Harnett County
420 McKinney Pkwy
LILLINGTON, NC 27546
Phone:
Fax:

SUBJECT: SFD2106-0027
SINGLE FAMILY DWELLING

Here are the results of all Inspections located at **140 THORNTONS CREEK DR:**

Inspection Type: ROUGH IN SFD CRAWL

1ST FLOOR HEADER 2ND FLOOR FRAMING

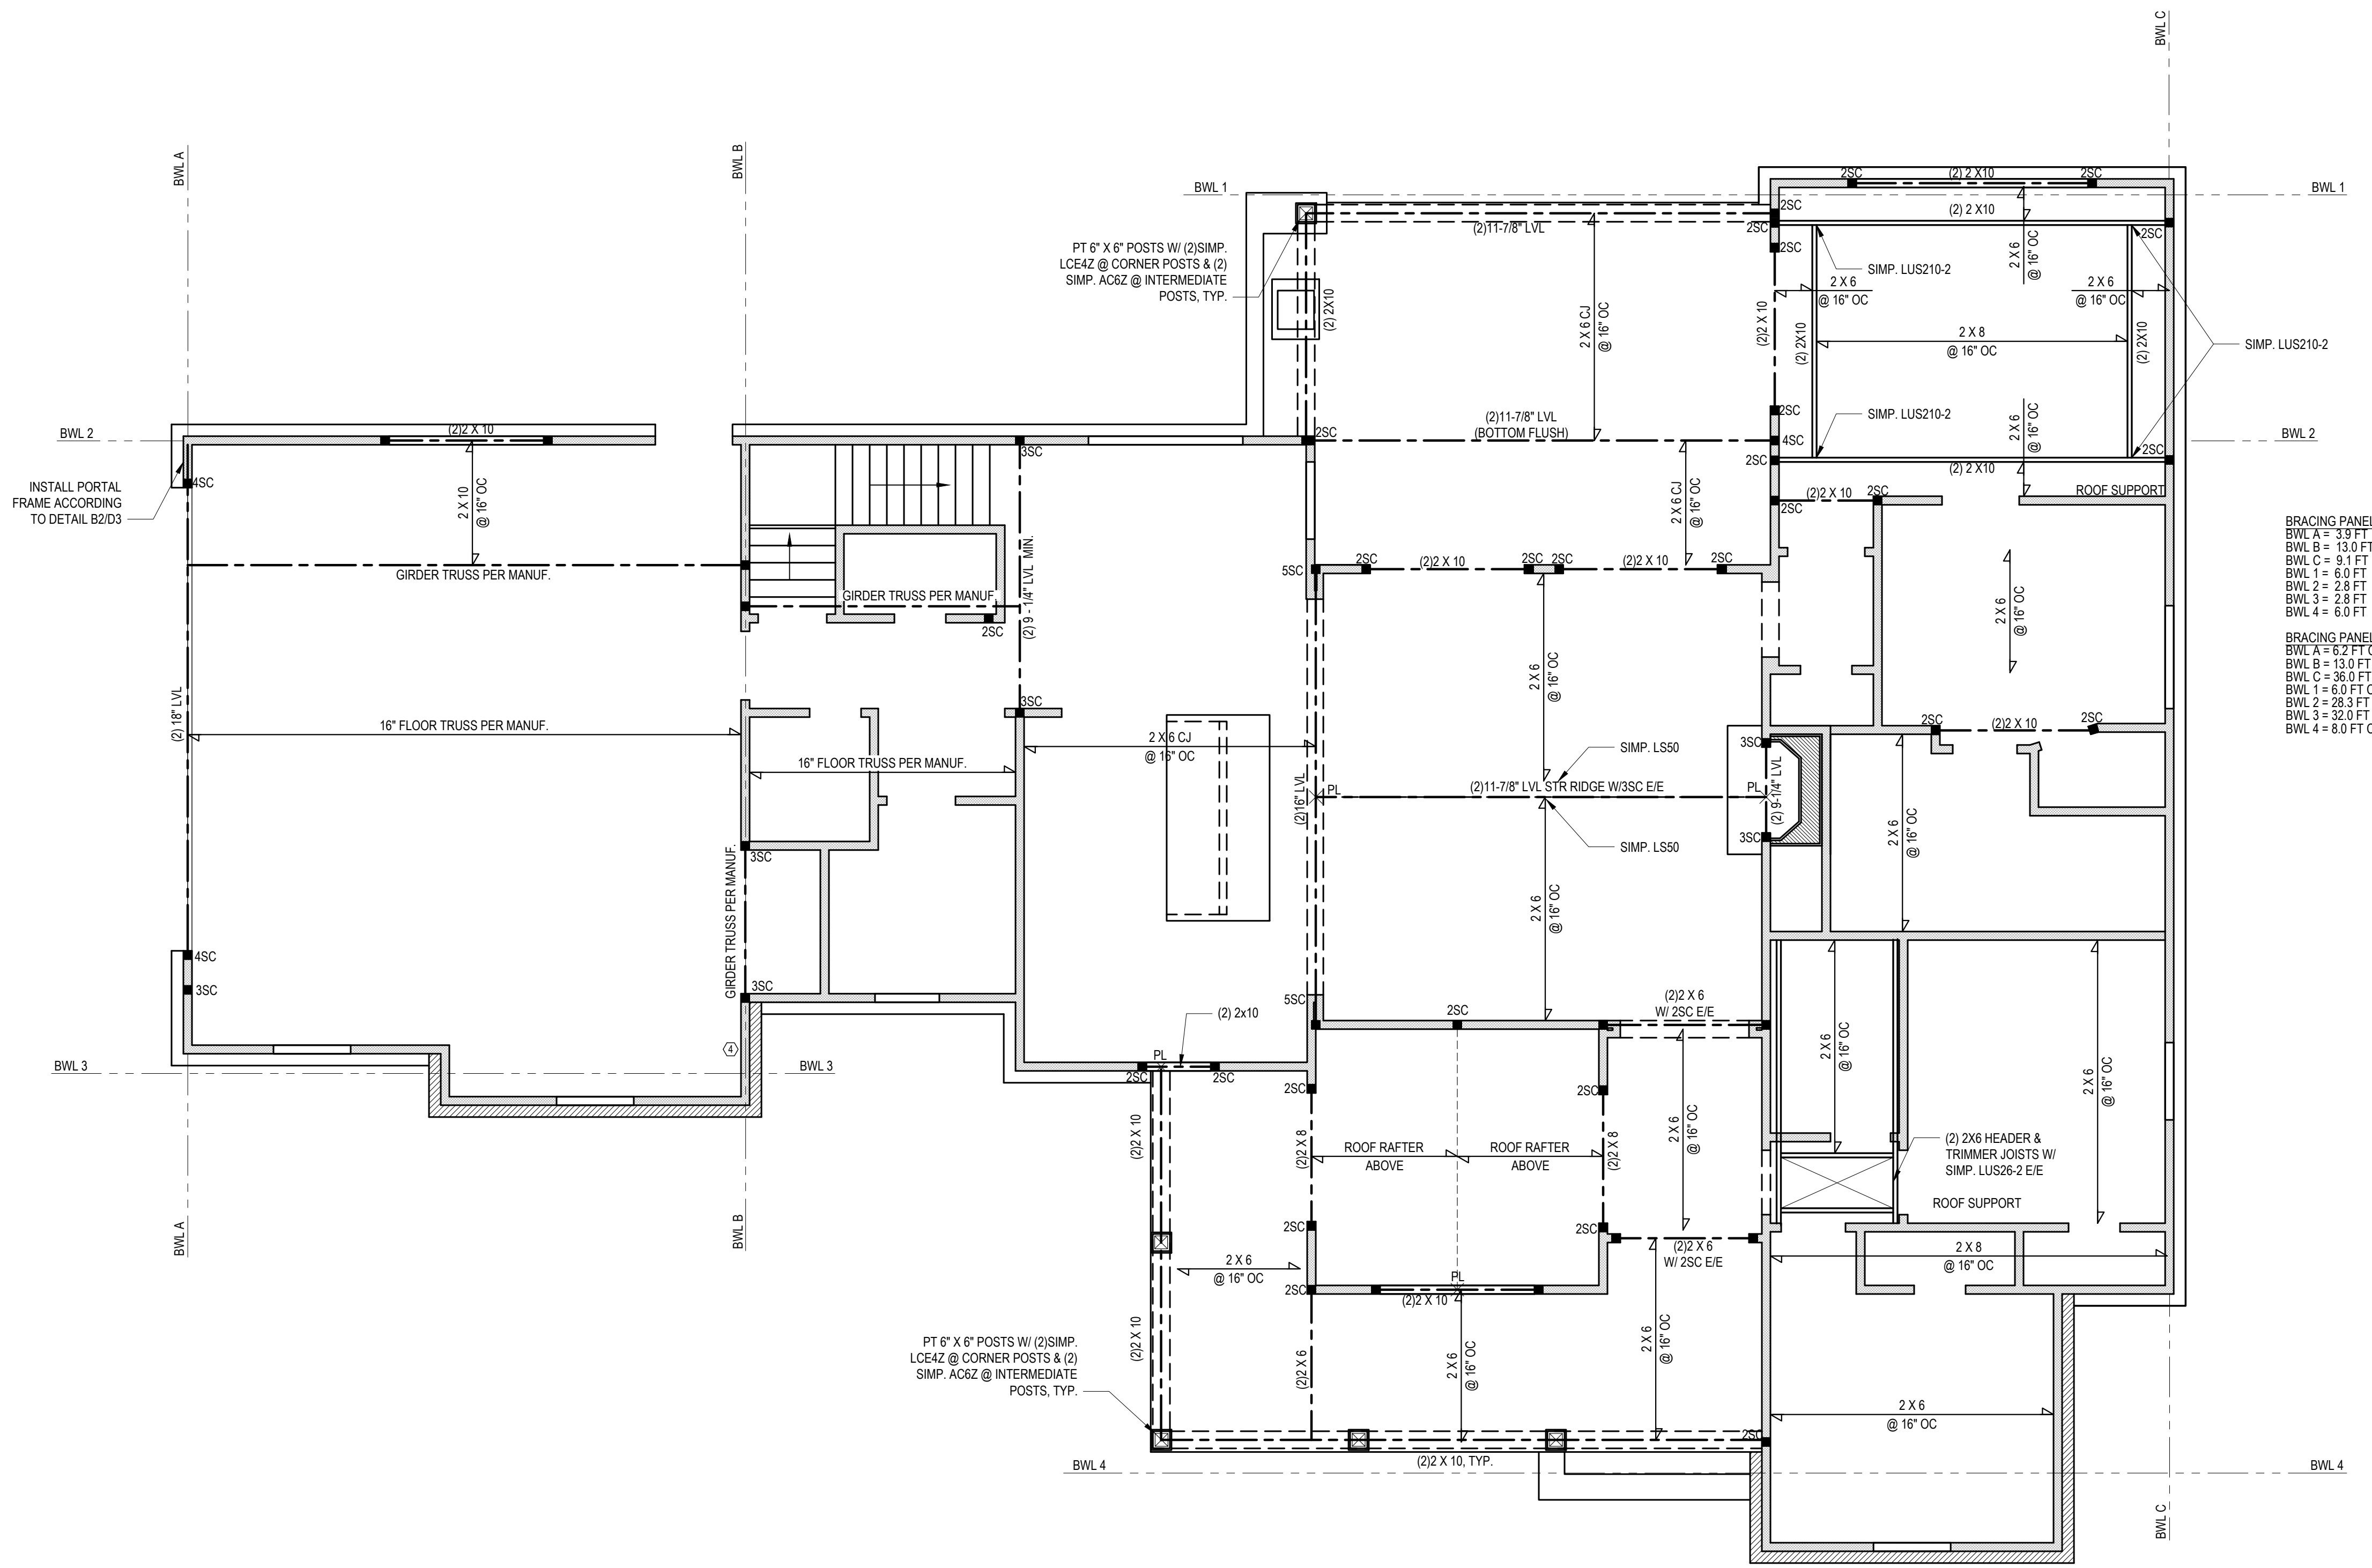
1. Portal frame bolts loose and a few anchor bolts in garage 2. Can't notch jack stud at bottom plate at portal bolt 3. Missing jack studs on both sides of garage header 4. Duct work needs to be protected at stairs 5. Mid point strap on plumbing line 6. Need approved fire stop at plumbing line in garage and missing at water closet next to garage , dryer vent pipe , left closet by stair 7. Need 100 psi on test 8. Missing king under 9 1/4 lvl per plans 9. Missing header over return and need to be boxed in 10. Missing king on fire place lvl right side 11. Notched front porch beam at kitchen window 12. Need to strap sc in front right bedroom front porch, 4sc in master 13. Need to add king on each side of master window 14. DWV no water in test 15. Air barrier need to be sealed upstairs 16. Missing window 17. Missing fire stop upstairs closet, behind shower Stopped inspection. Need to look at roof system and need layout for trusses in garage.

1. Portal wall frame bolt still loose 2. Need to seal wires at top plate above panel 3. Need air barriers under stairs 4. Electrical box next to return needs to be secured 5. Top plate above return needs to be sealed 6. Seal hvac chase by stairs 7. No layout for trusses in garage 8. Air barrier needs to be sealed and installed up stairs 9. Holes in top plates & bottom plates upstairs need to be sealed 10. All rafters need to be full bearing 11. Missing nails in joist hangers in garage 12. Need load point blocking above left side of top plate in garage for lvl valley 13. missing nails in hangers on back porch and in master bedroom 14. Strap stud columns under lvl in living room 15. Missing nails in hangers on front porch 16. Window still missing upstairs
